KIRKLEES METROPOLITAN COUNCIL INVESTMENT & REGENERATION SERVICE

DELEGATED DECISION TO DETERMINE APPLICATIONS FOR CONSENT, AGREEMENT OR APPROVAL REQUIRED BY CONDITION

Reference No:	2023/44/93699/E
Site Address:	Strines Lodge, Penistone Road, High Flatts, Huddersfield, HD8 8XU
Description:	Discharge conditions 5 (tree planting), 6 (tree protection), 7(Arboricultural Method Statement) on previous permission 2023/92449 for erection of single storey rear extension with internal and external alterations (within a Conservation Area)
Recommending Officer:	Nicole Helliwell

Officer Report

Tree Planting Plan

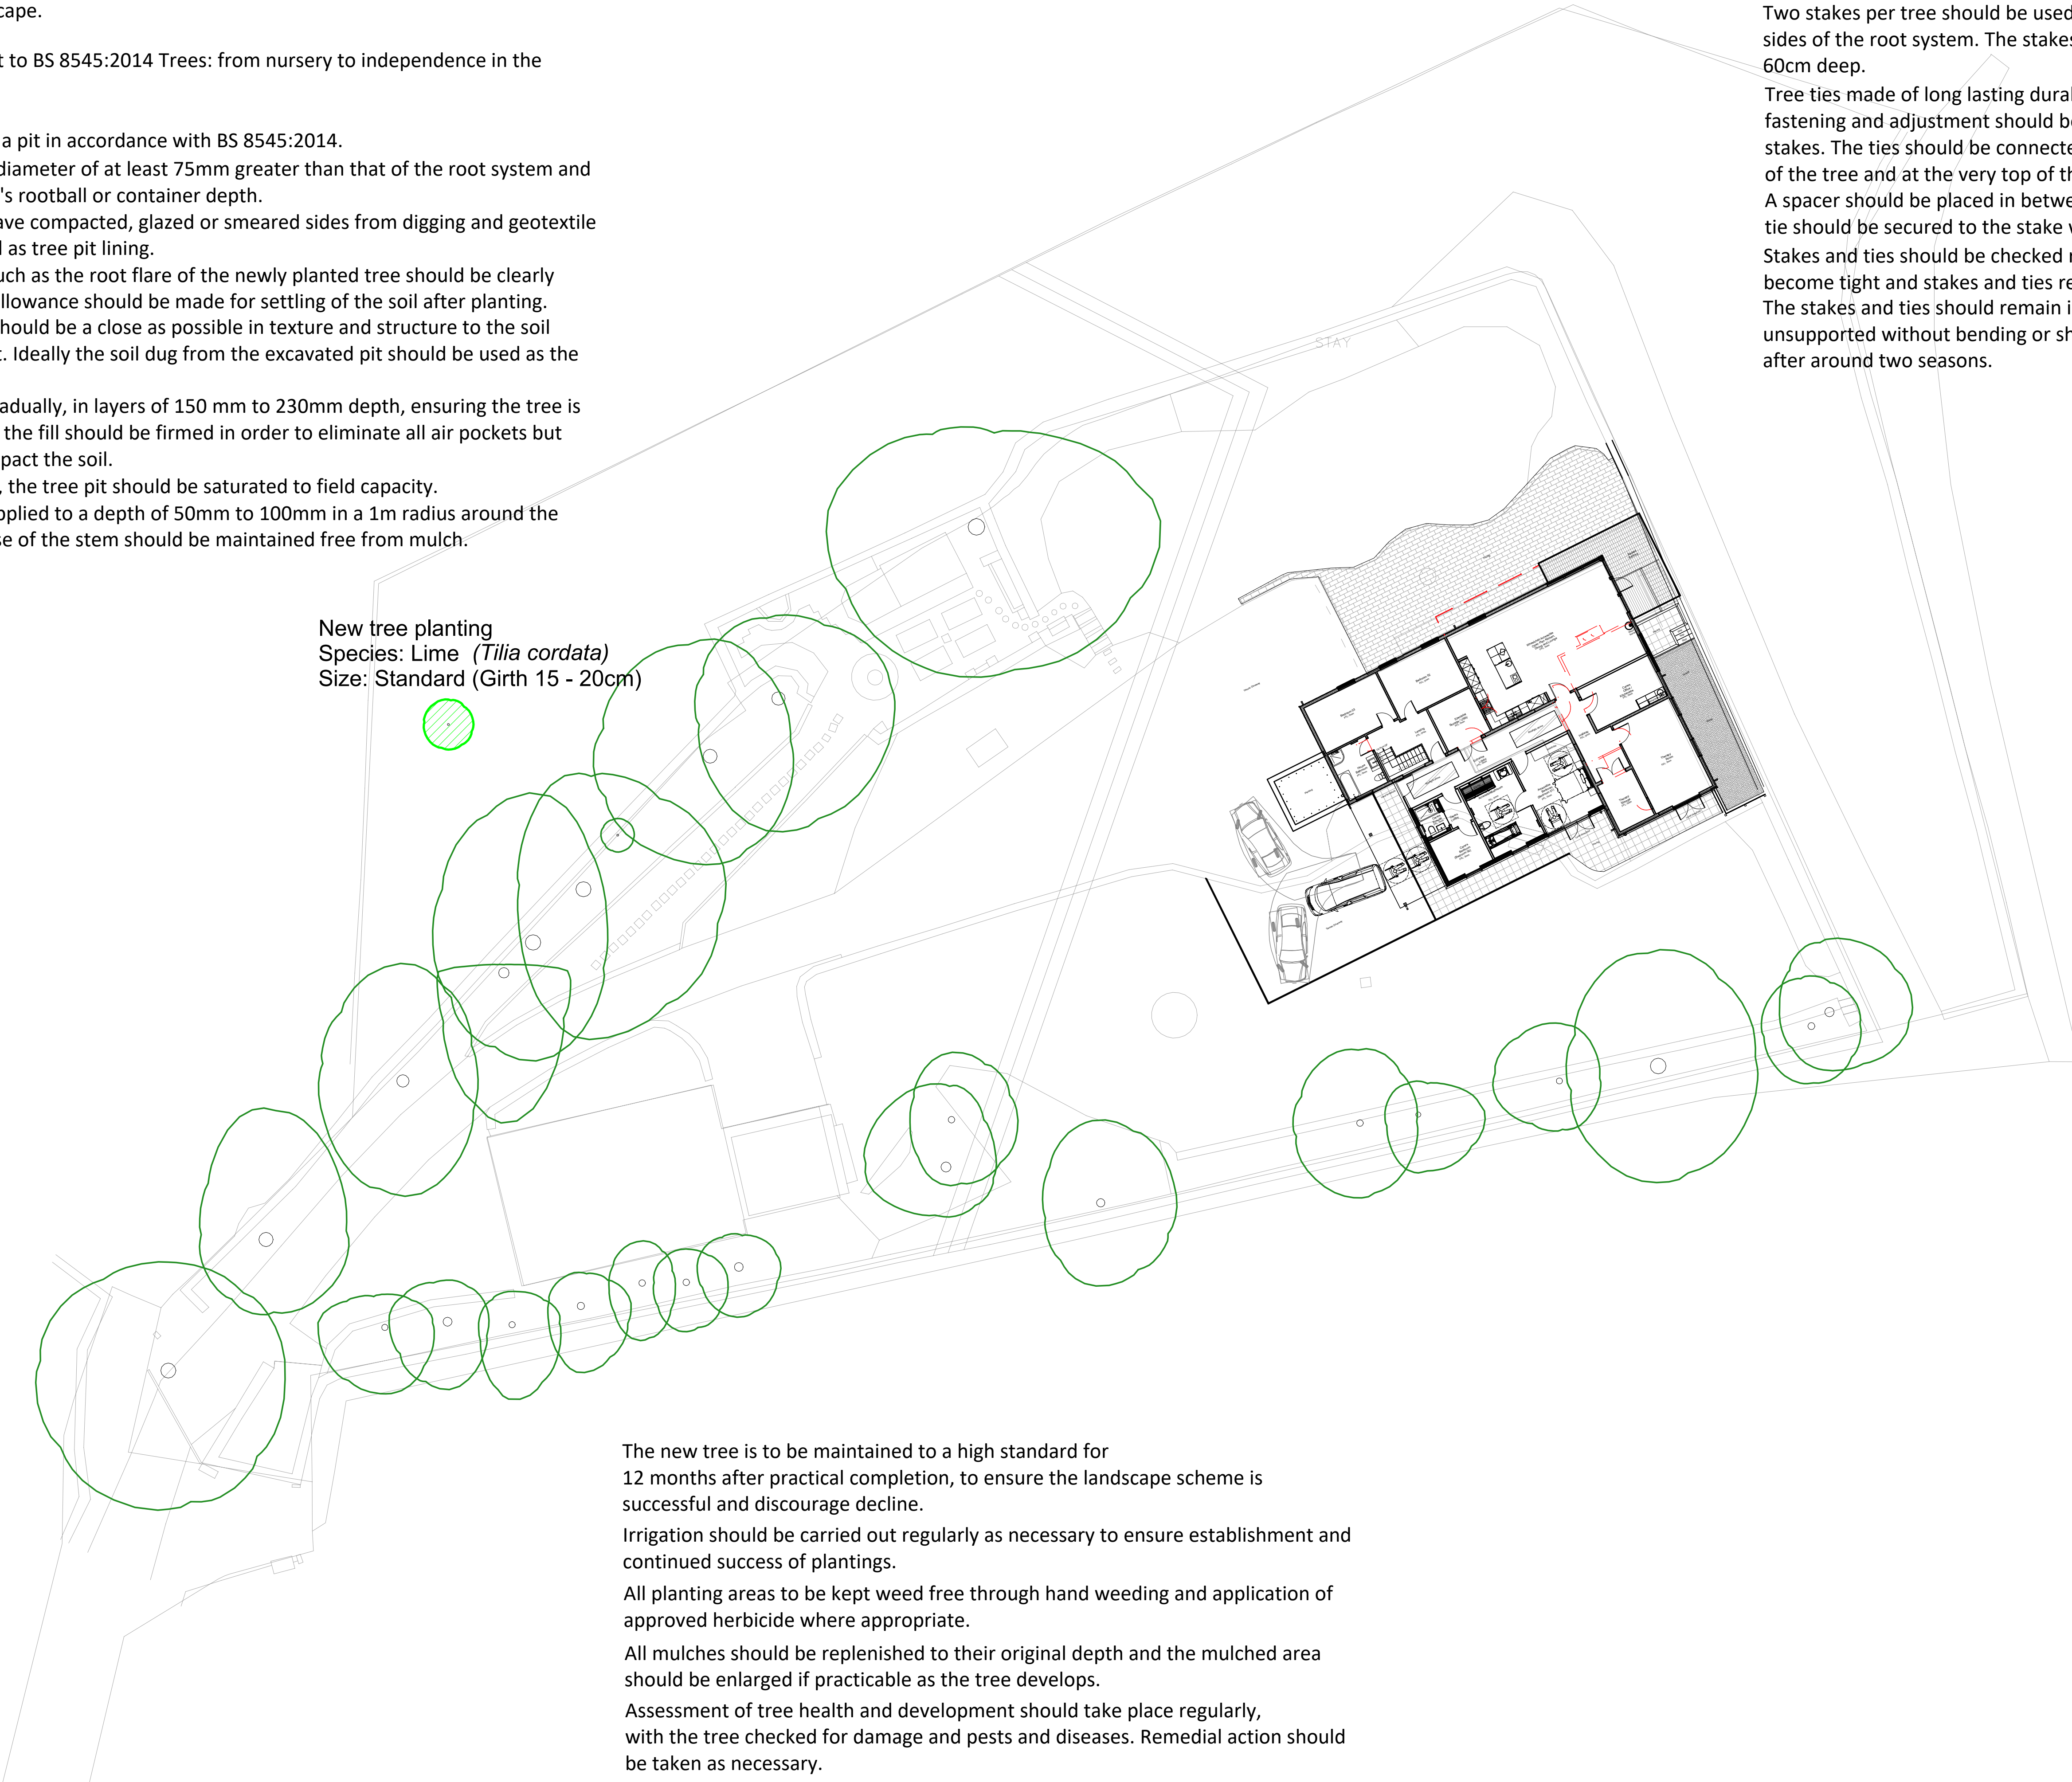
To discharge condition 5, a plan titled Tree Planting Plan (reference. AWA5682) has been submitted. The details on the plan are acceptable for the first part discharge of the condition. However, for the full discharge the new tree will need to be planted to the agreed detail in the first available planting season following the commencement of the approved development. The 2023/2024 planting season would typically end at the end of March 2024. Depending on weather, it could be sooner/later.

The details on the plan are acceptable for the first part discharge of the condition. However, for the full discharge the new tree will need to be planted to the agreed detail in the first available planting season following the commencement of the approved development.

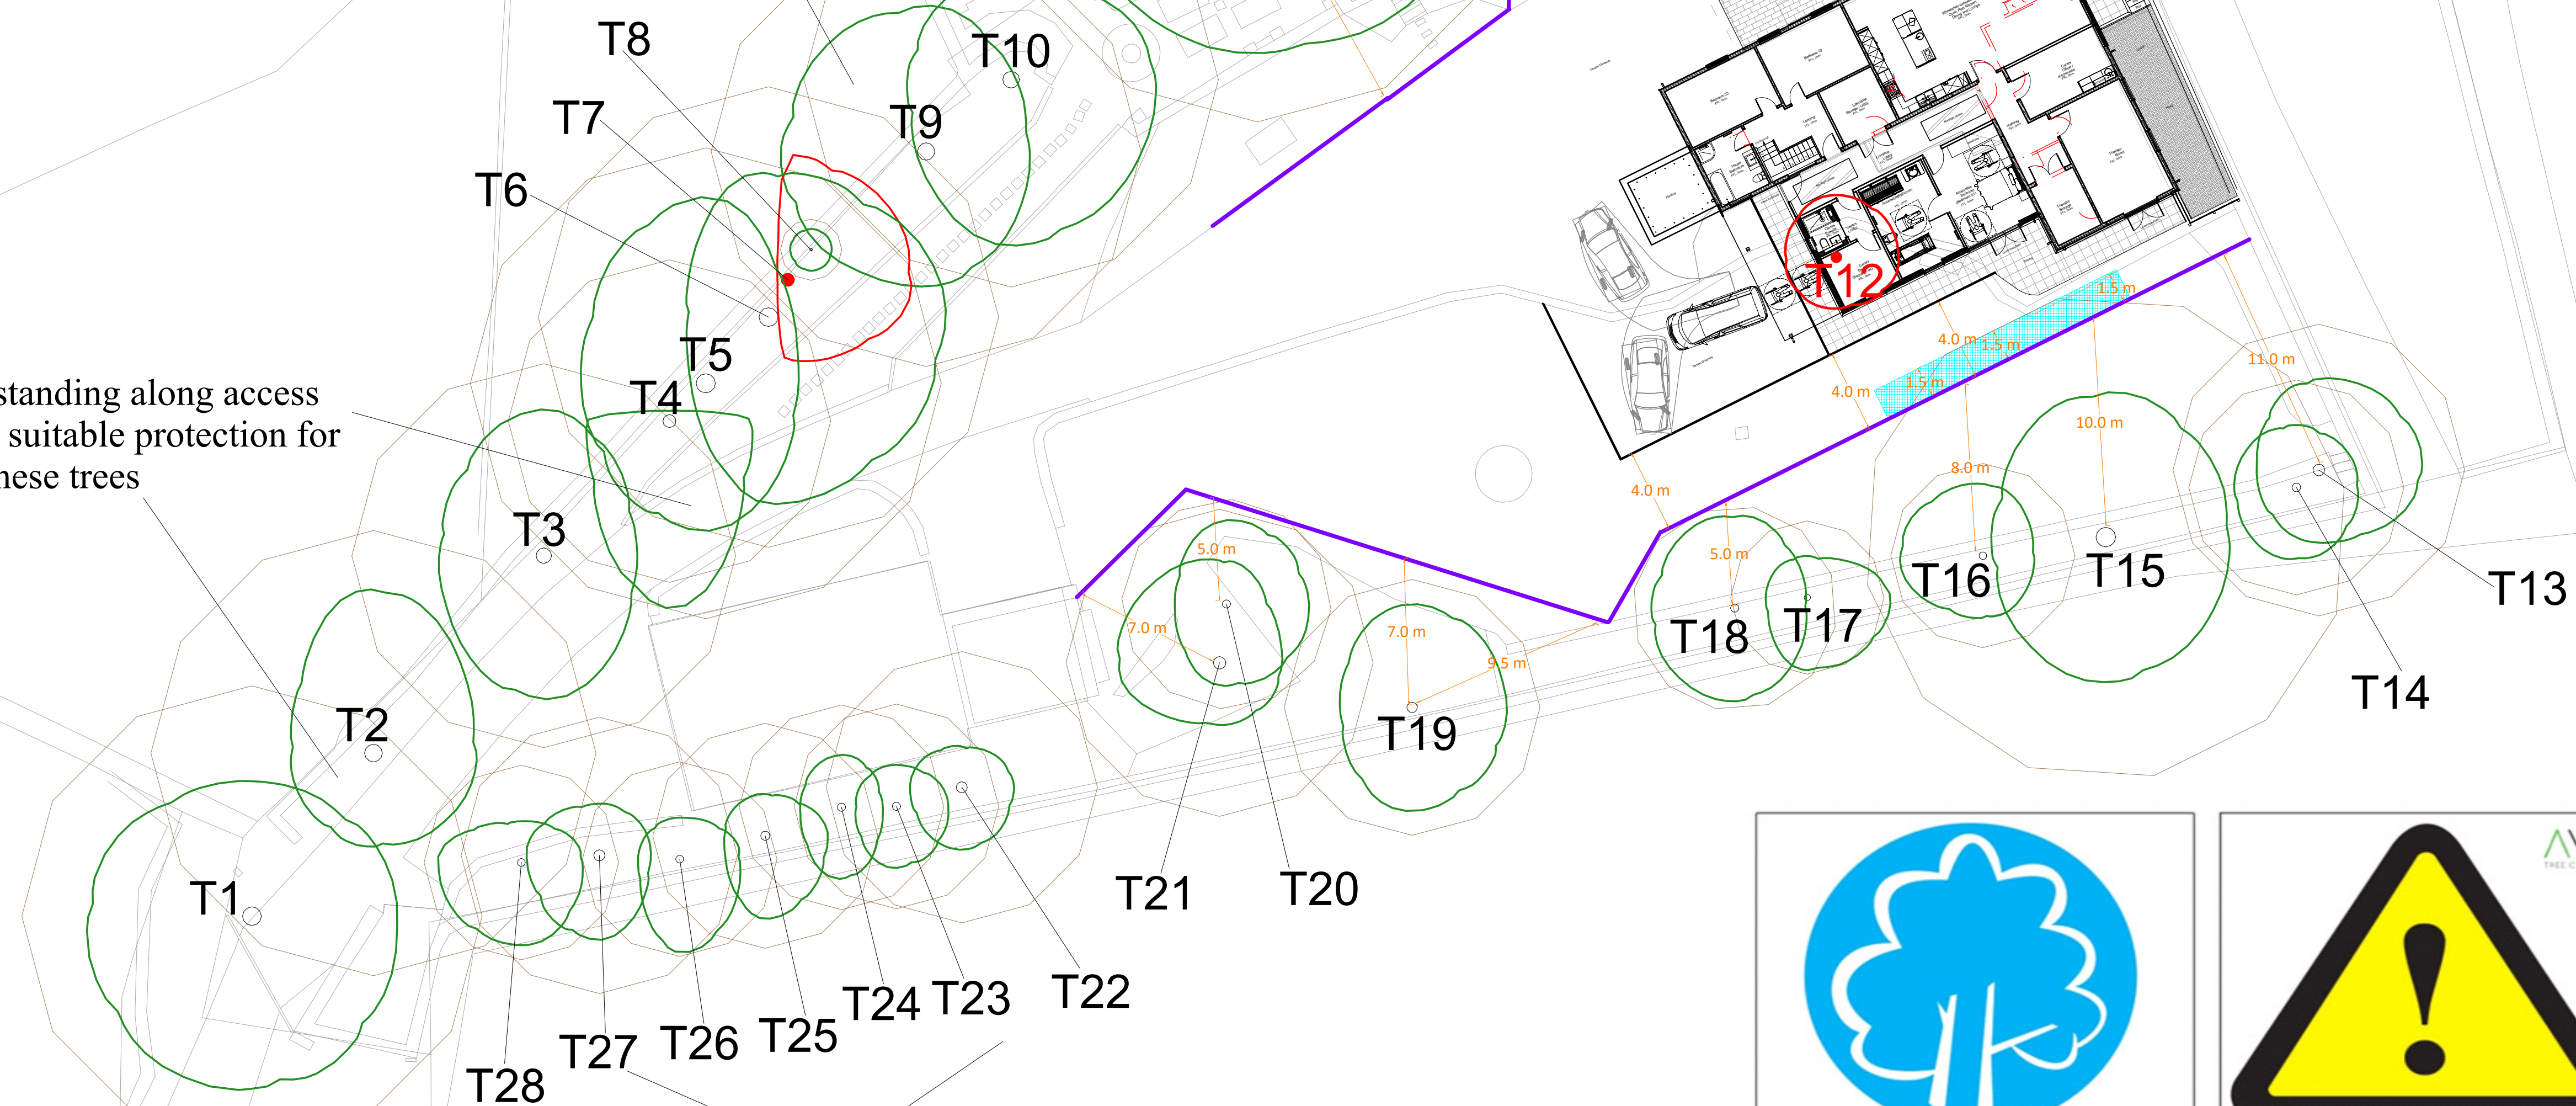
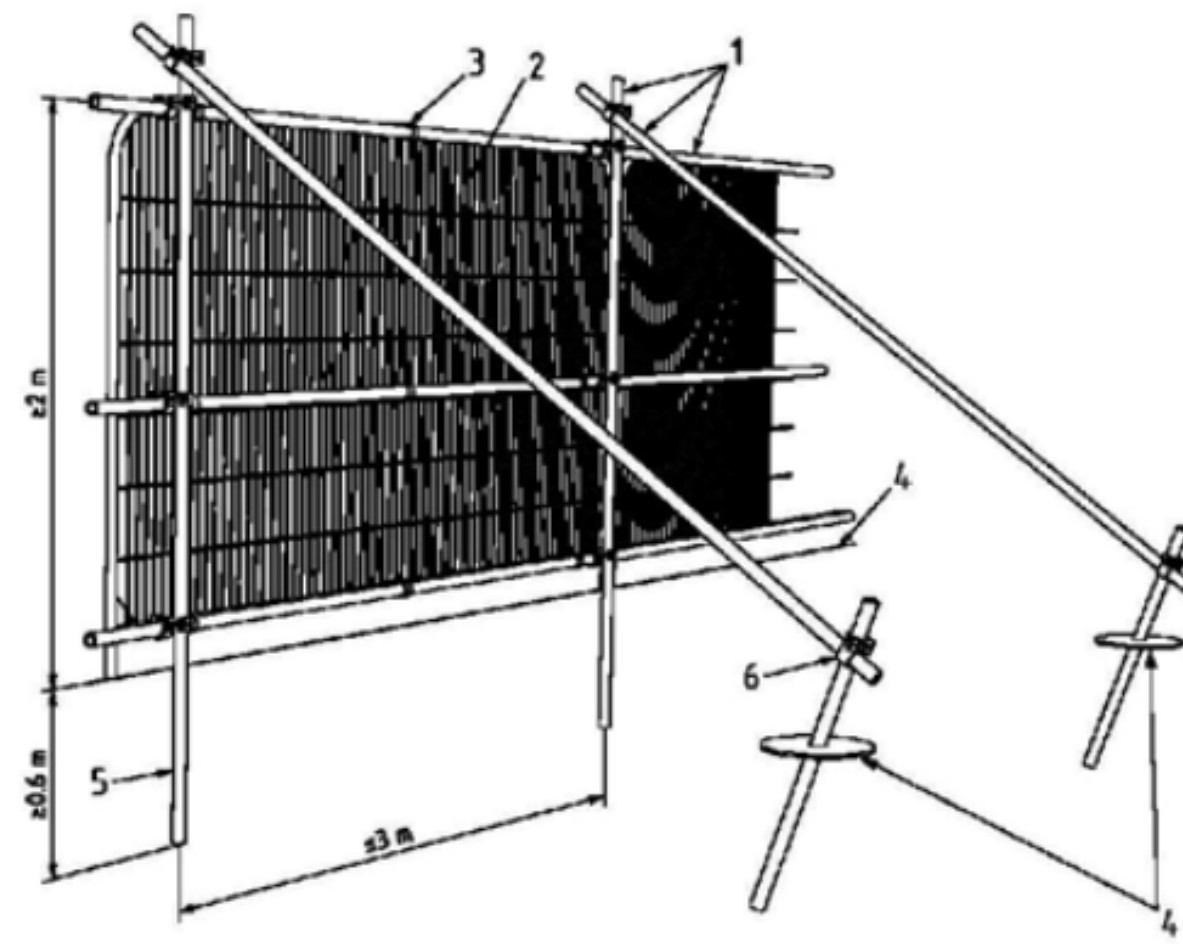
The details for both these conditions can be found within Arboricultural Method Statement (AMS) (Reference: AWA5770AMS). Providing the sequence of operations and the accompanying detail within the AMS are followed and the tree protection plan shown in Appendix 4 are implemented during the development as described, the retained trees at the site will be suitably protected during the development. Therefore, the AMS is acceptable for the discharge of condition 6 and 7 from a tree perspective.
